CITY OF ALBUQUERQUE

August 14, 2013

Re: Garfield Apartments, 501 Girard SE, All units
Request for Permanent C.O. –Accepted
Engineer's Stamp dated: 2-08-12, (K16/D079)
Certification dated: 7-26-13

GRADING & DRAINAGE PLAN

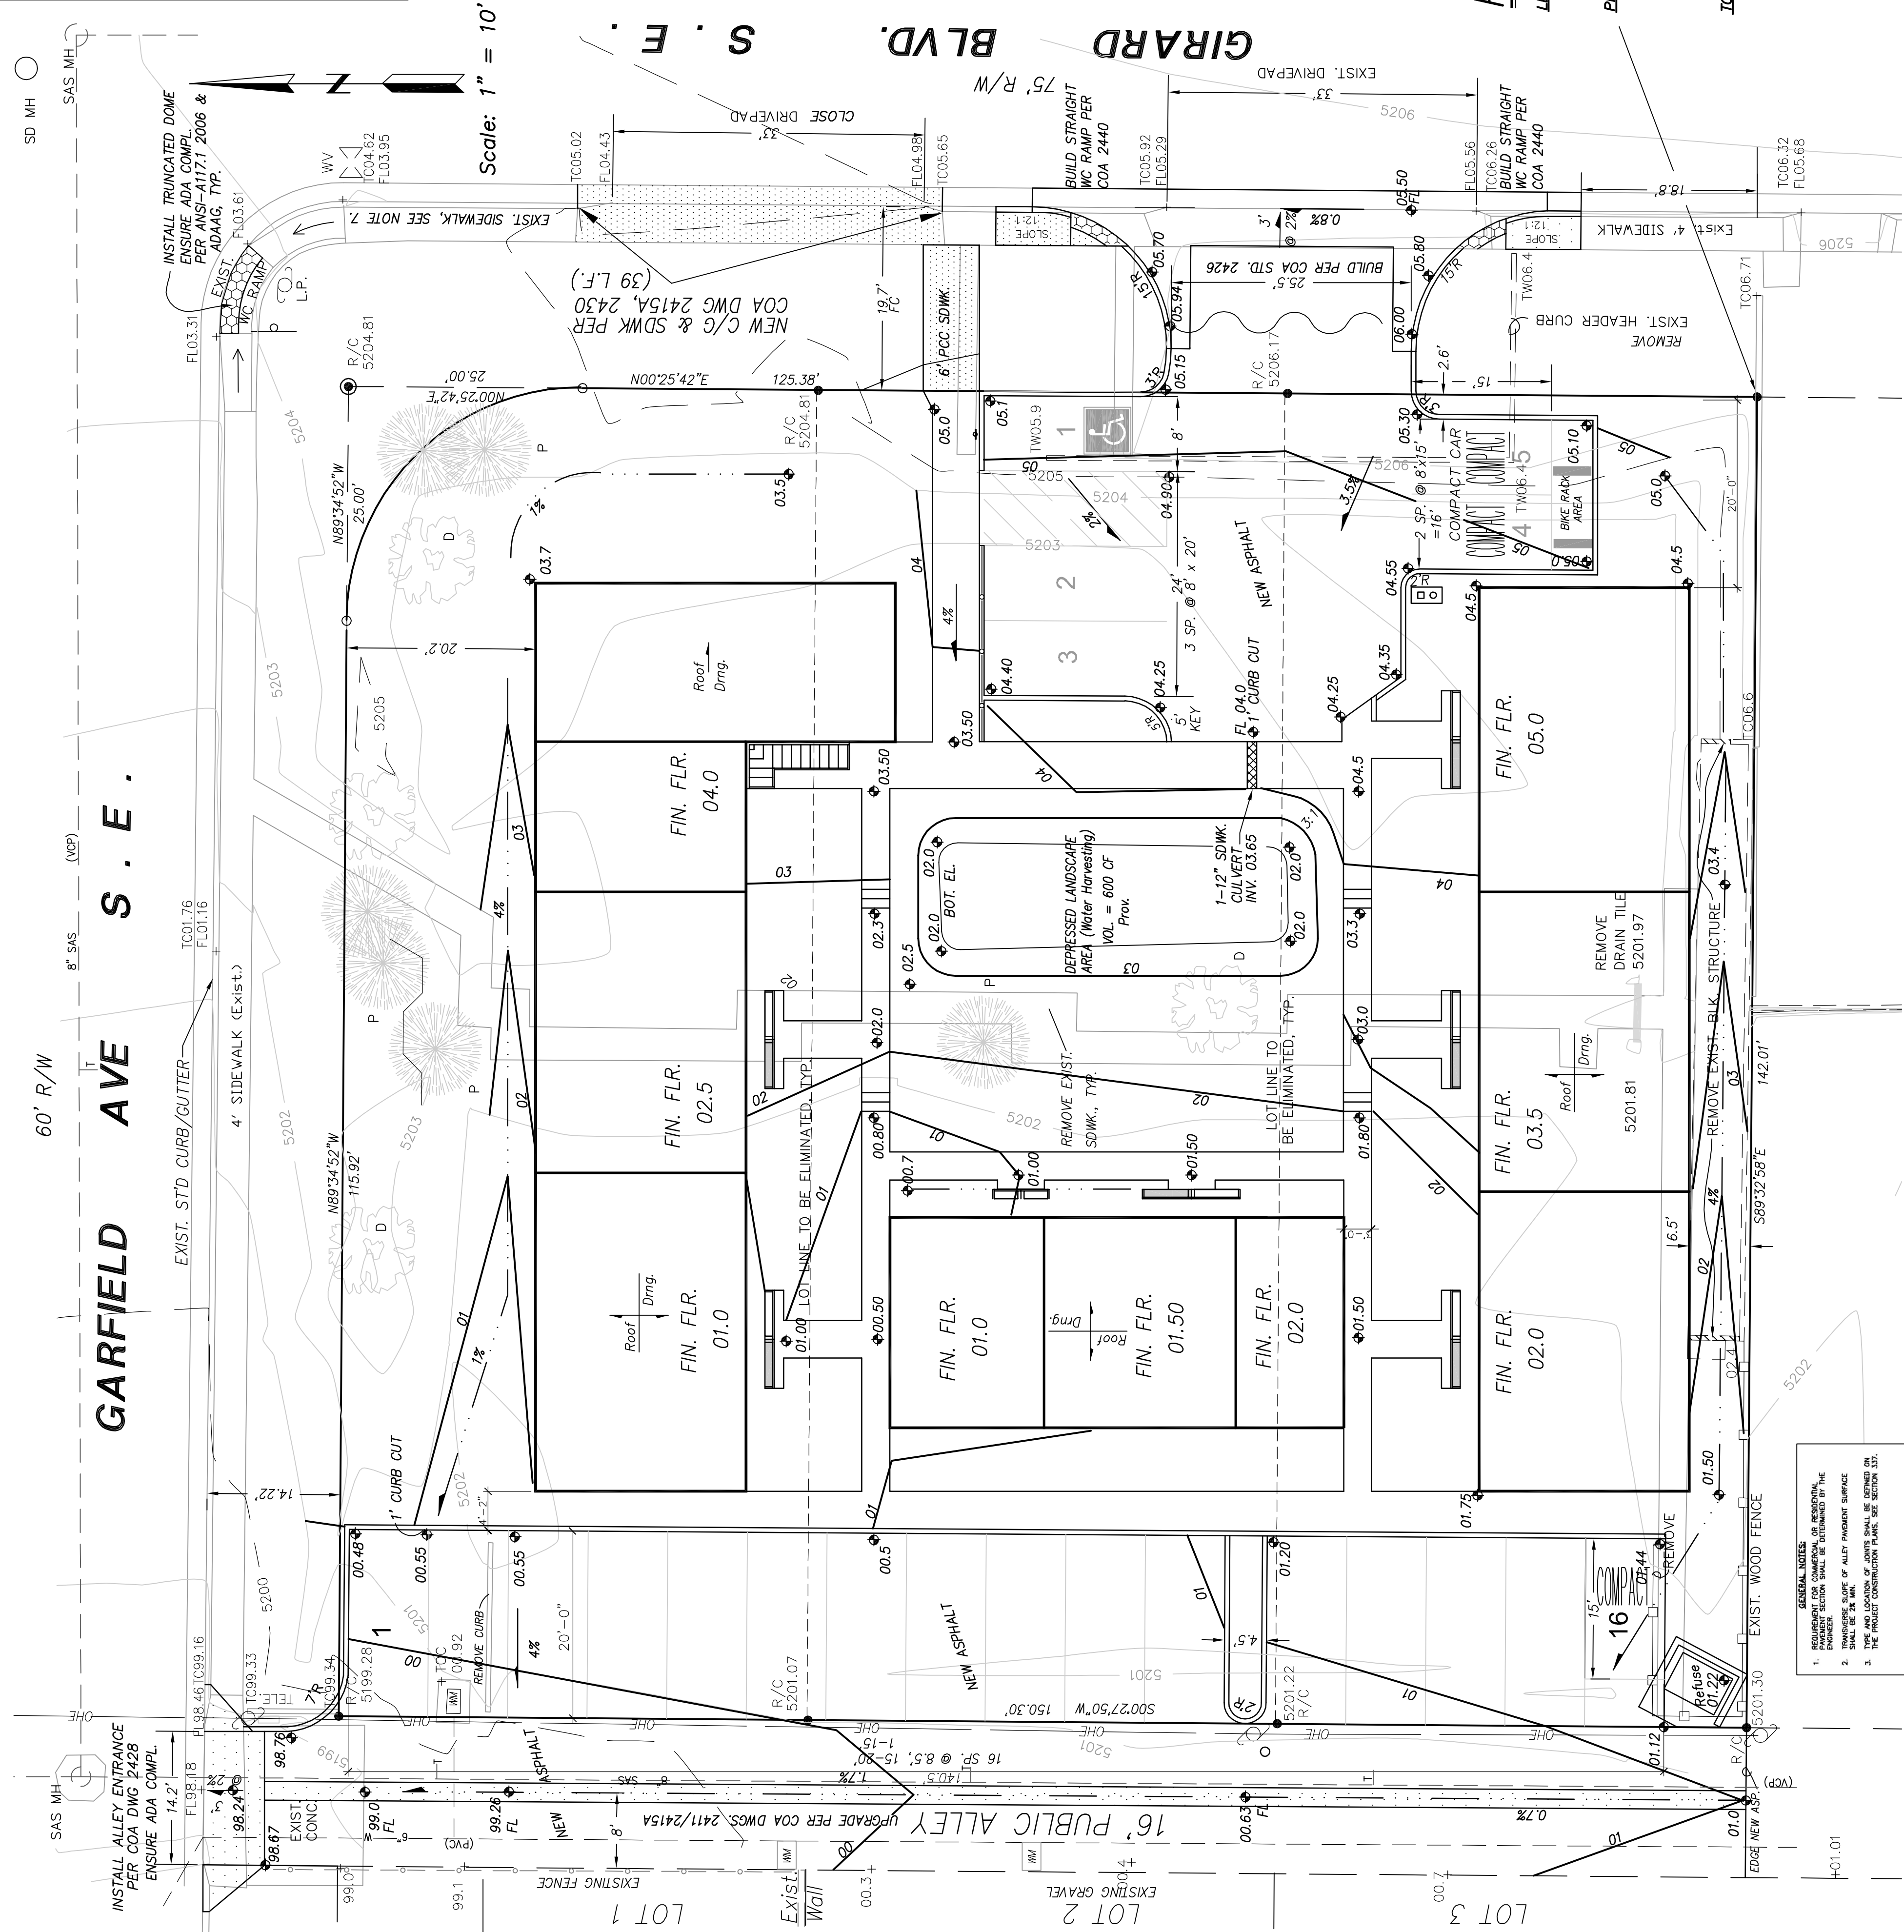
Based upon the information provided in the Certification received 07-26-13 and e-mail received August 12th, 2013, the above referenced Certification is acceptable for a release of a Permanent Certificate of Occupancy by Hydrology.
